Recommendation Report for Planning Permission for Works or Extension to a Dwelling

REF NO: FG/150/19/HH

LOCATION: 4 Downview Road
Ferring
BN12 6QR

PROPOSAL: Single storey side/rear extension and roof extension.

project:	4 DOWNVIEW ROAD, FERRING BN12 6QR		
client:	MR & MRS DEVITT-SPOONER	job ref:	SI233
title:	PLANNING APPLICATION	scale 1:50 & 1:100 @A1	
date	December 2019	dwg no: PL01	rev: A

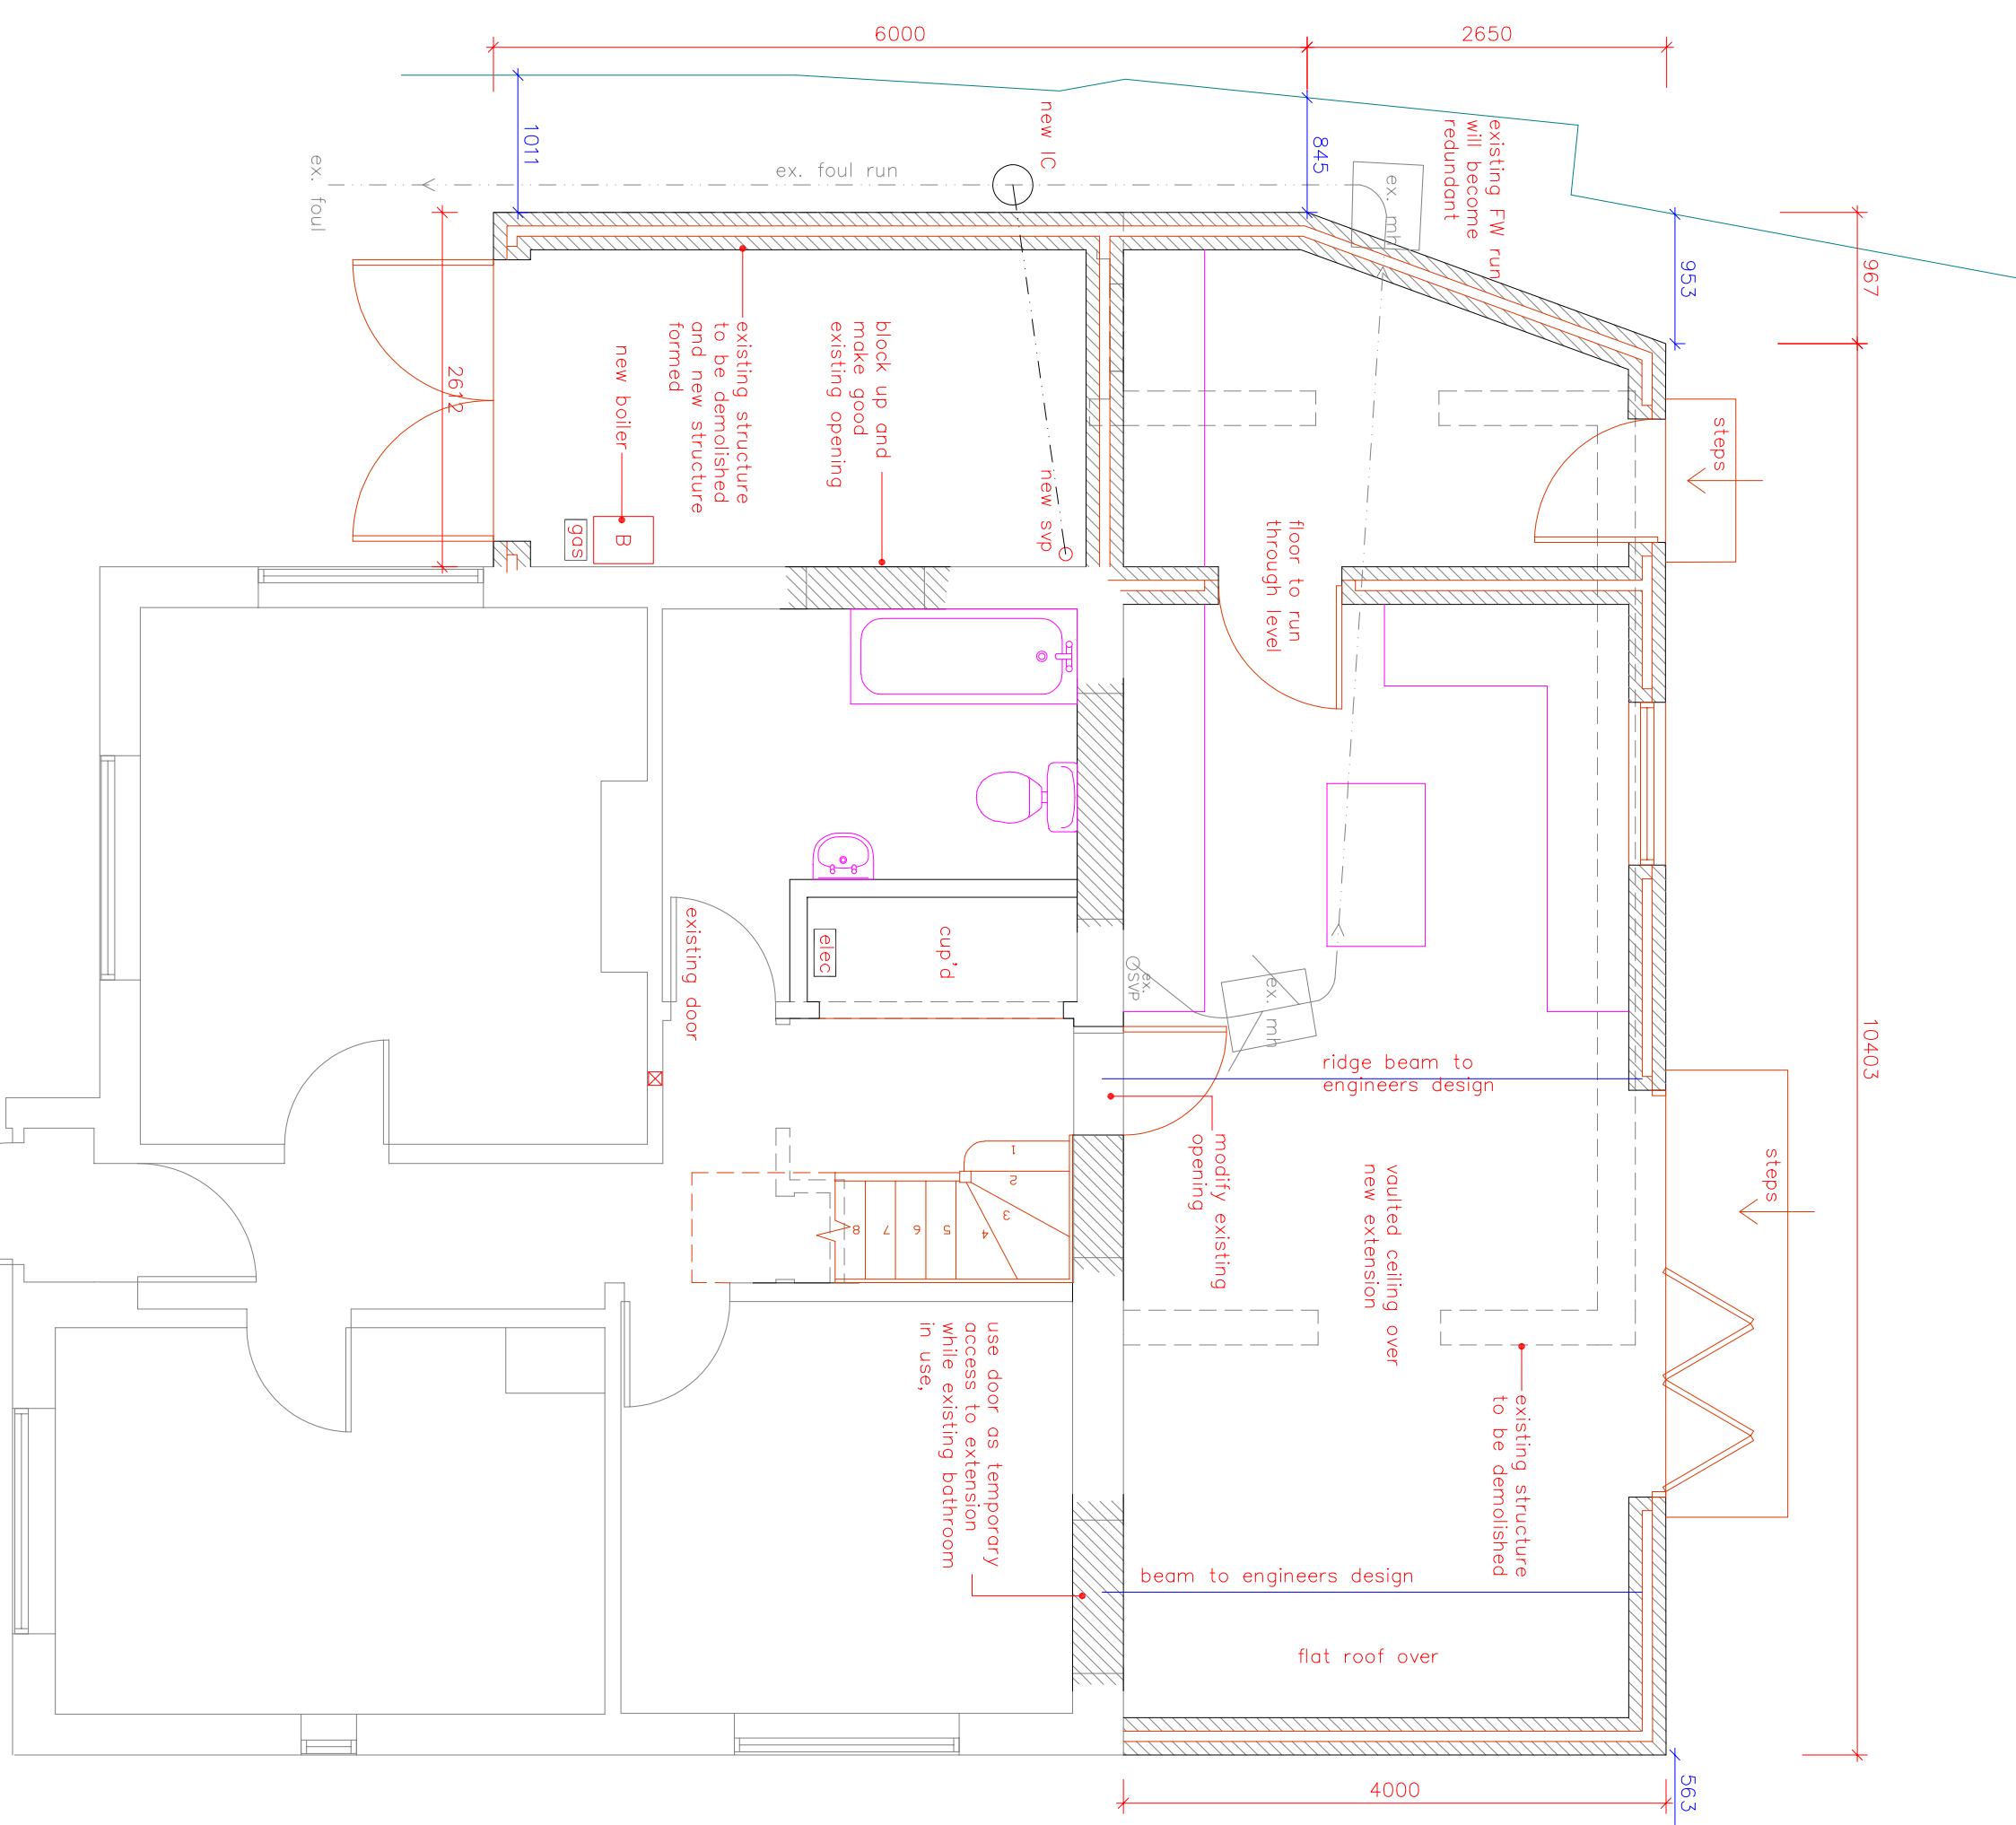
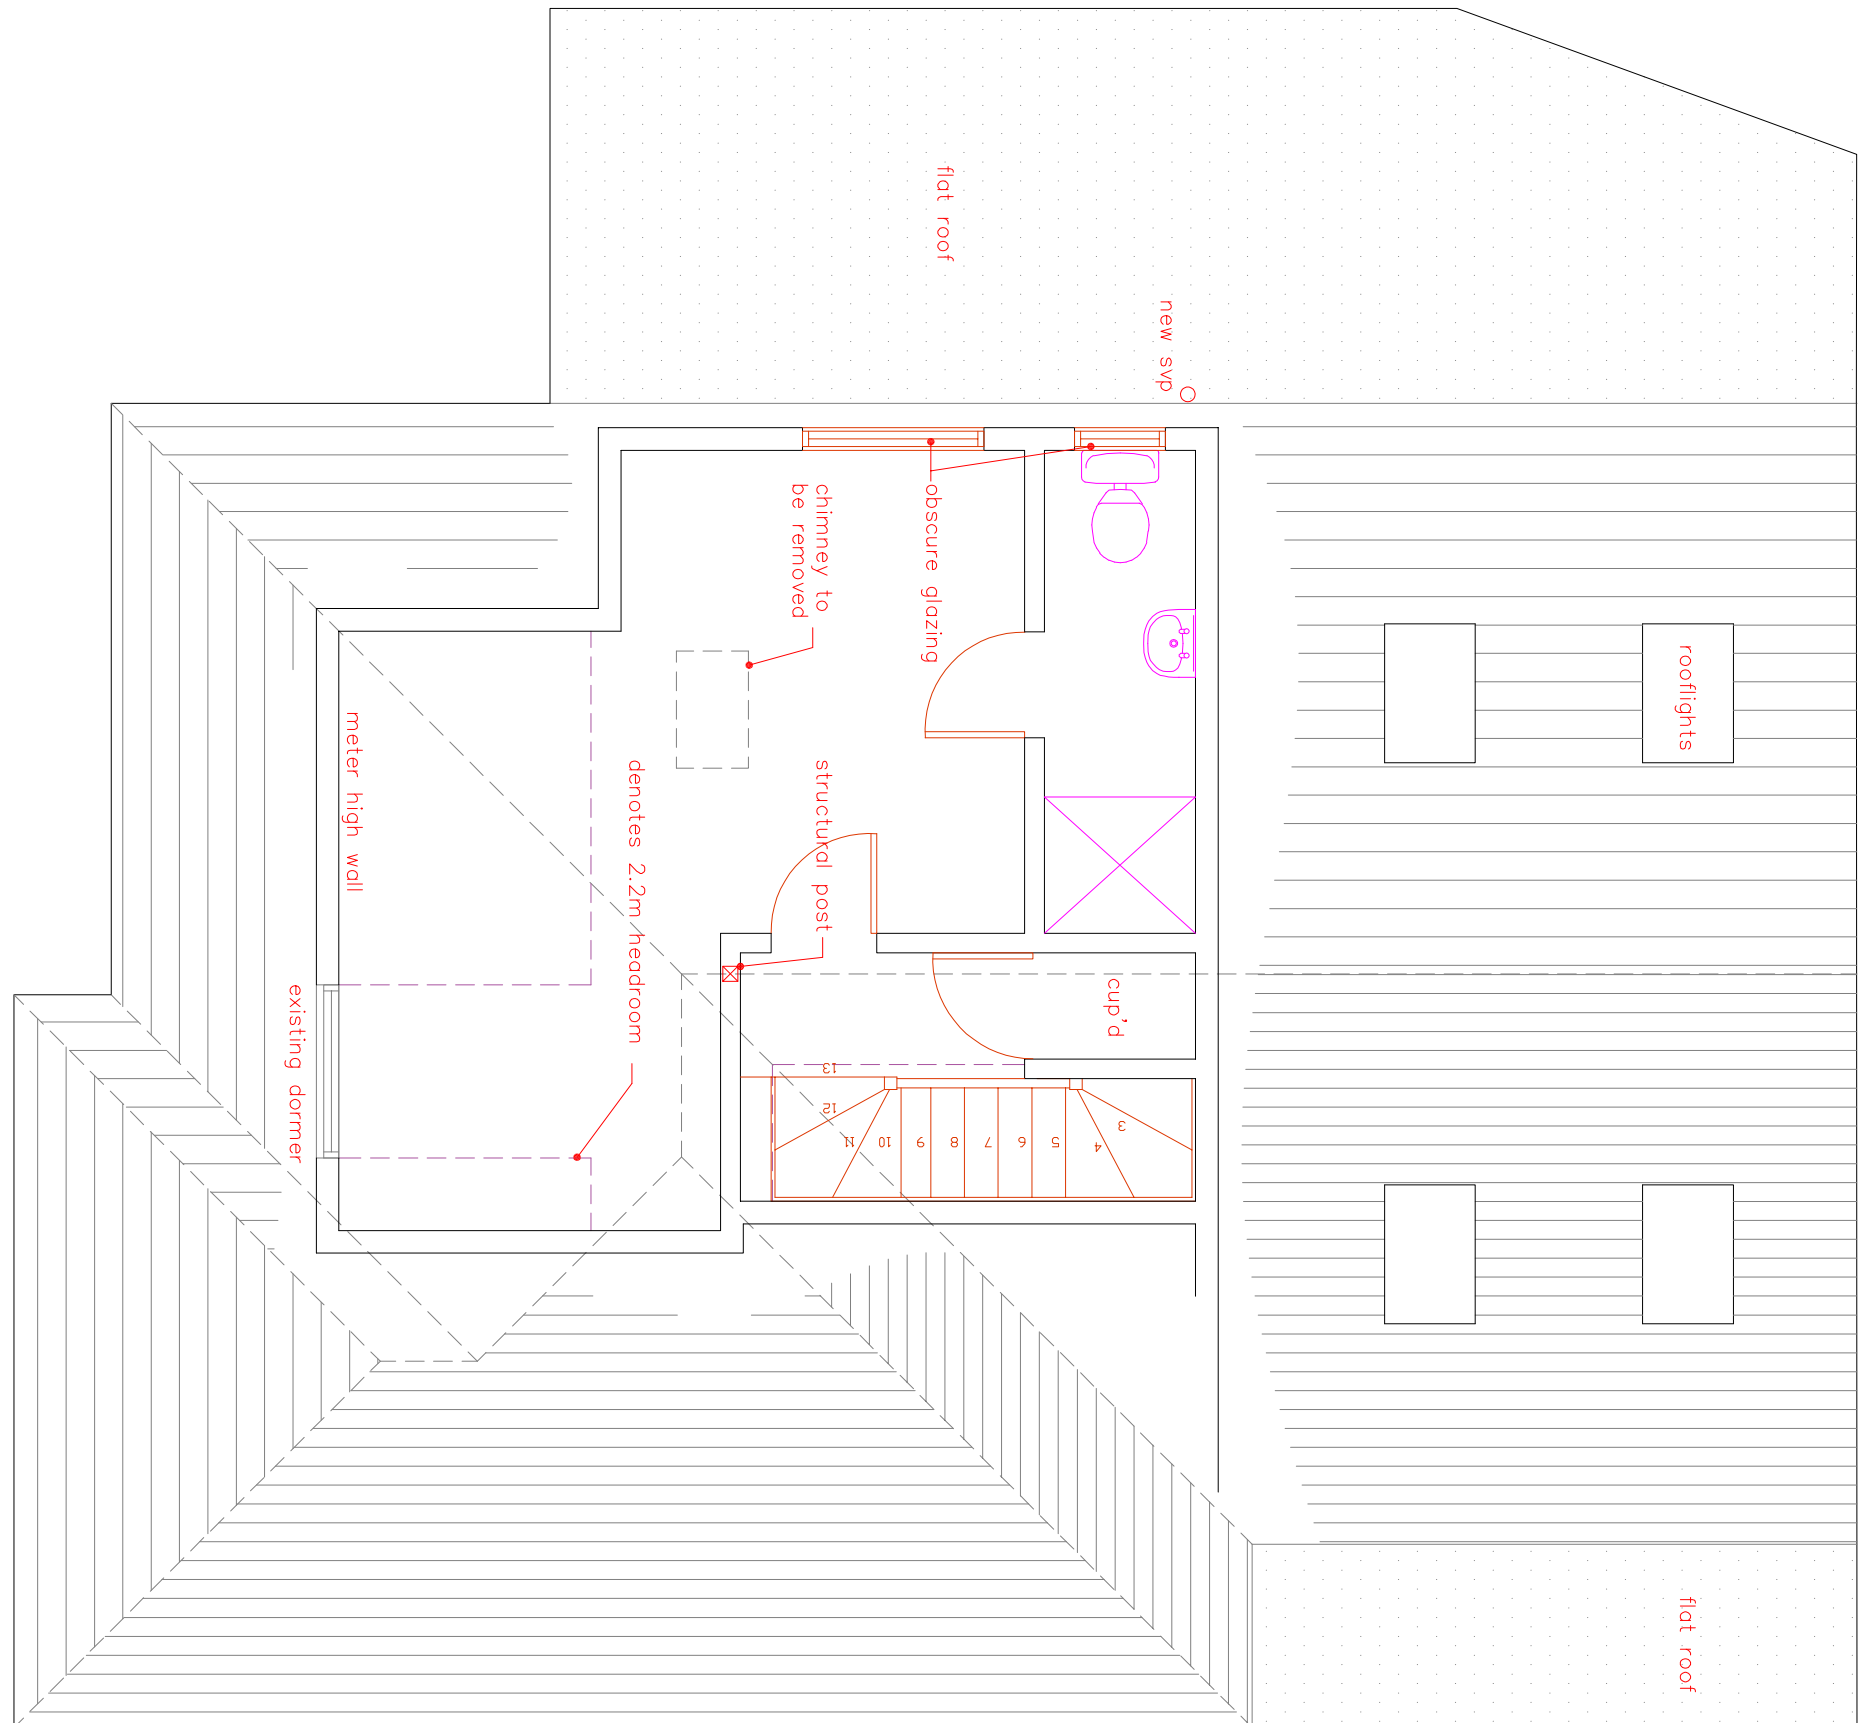
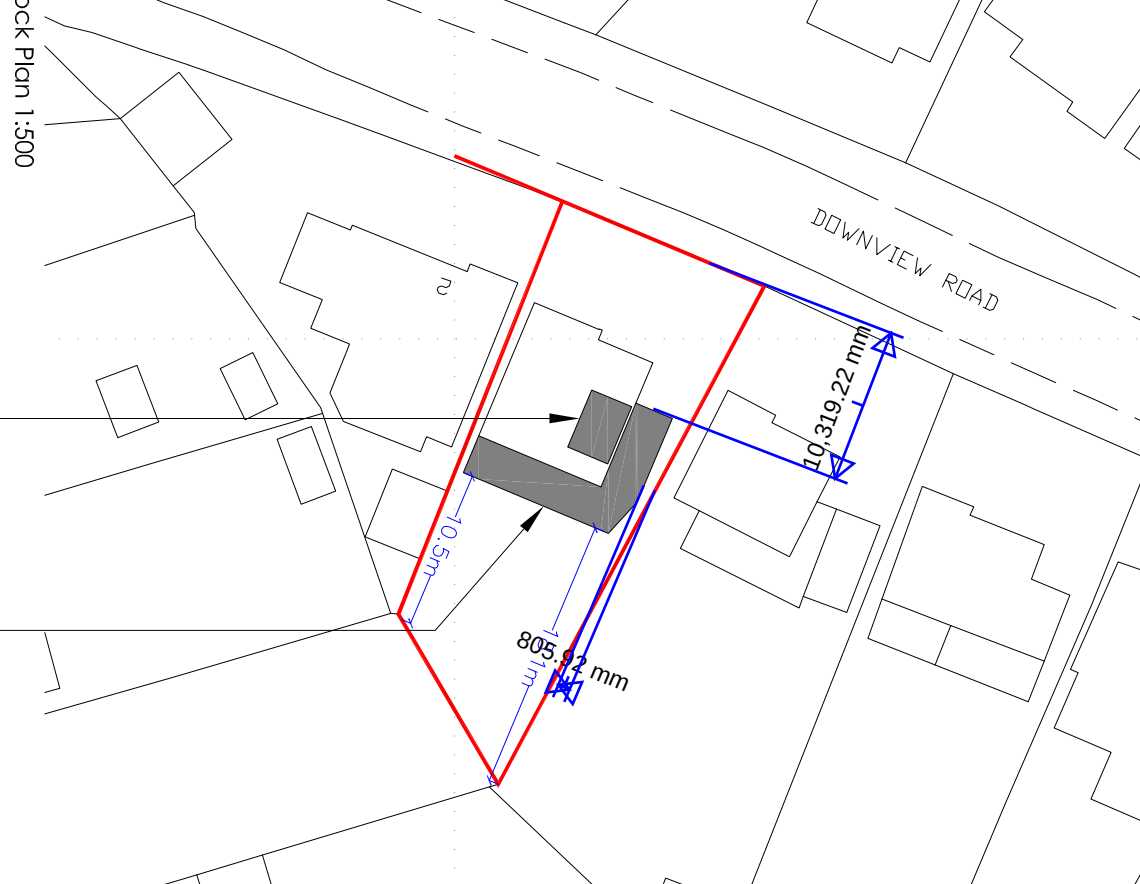
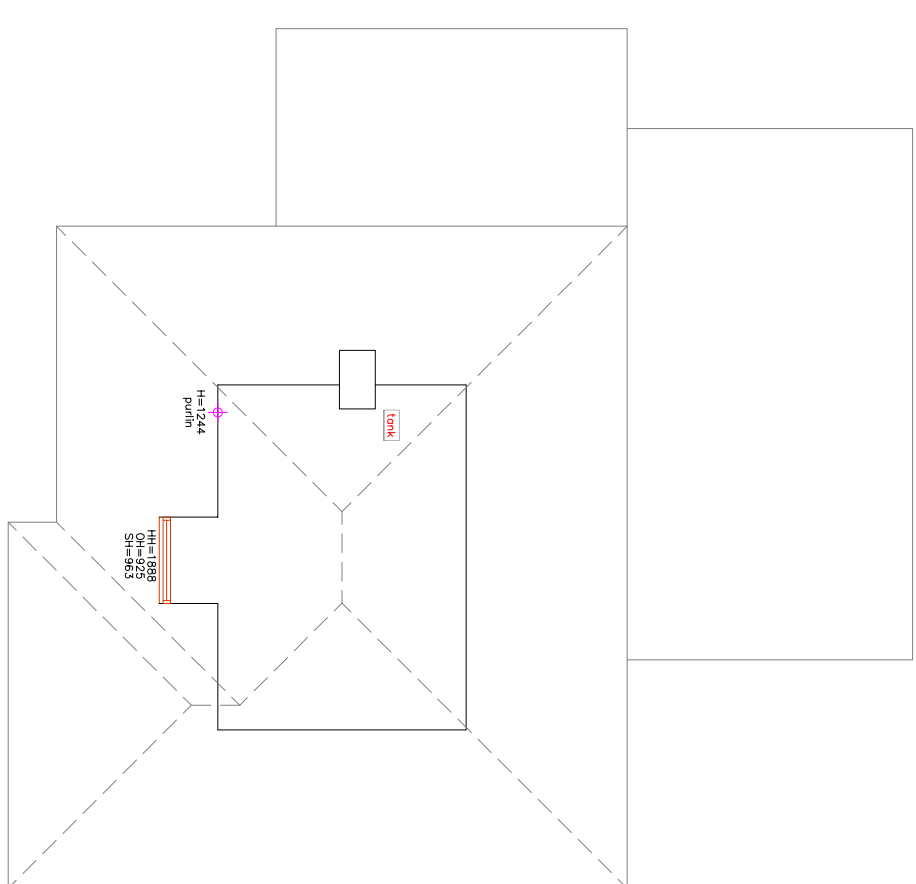
The proposed side and rear extension will be visible from the street scene, as it wraps around the Northern and Eastern elevations of the host dwelling. Therefore, there will be views of the Northern element of the proposal from the public realm. These additions are significant, and will alter the appearance of the property. However, due to it being set back approximately 10m from the street scene, it is considered to have a reduced impact upon the character of the locality.

The proposed roof extensions are considered to be acceptable additions to the host dwelling. The rear element of the proposal is considered to be a sympathetic, and well integrated addition to the host dwelling, as it matches the ridge height, eaves height and the roof slope angle of the existing dwellings roof. The proposed Northern dormer is considered to be subservient in appearance to the host dwelling, resultant of its scale, and siting on this roof slope. Furthermore, there are examples of similar proposals within the locality.

The proposed development is not considered to result in any significantly harmful impact upon the residential amenities of neighbouring dwellings. This is primarily due to the siting of the proposed extensions and the boundary treatment allowing for no significantly harmful overshadowing of the adjacent dwelling to the North. With regard to potential for overlooking, the proposed development is not considered to result in any harmful overlooking of adjacent occupiers, in that any proposed windows are either at ground floor level, or will be conditioned to be retained as obscure glazed in perpetuity.

Reason: For the avoidance of doubt and in the interests of amenity and the environment in accordance with policy D DM1 of the Arun Local Plan.
- 3 The windows at first floor level, on the Northern elevation of the proposed dormer shall at all times be glazed with obscured glass and, with the exception of any part of the window 1.7m above floor level, be fixed to be permanently non-opening, in perpetuity.
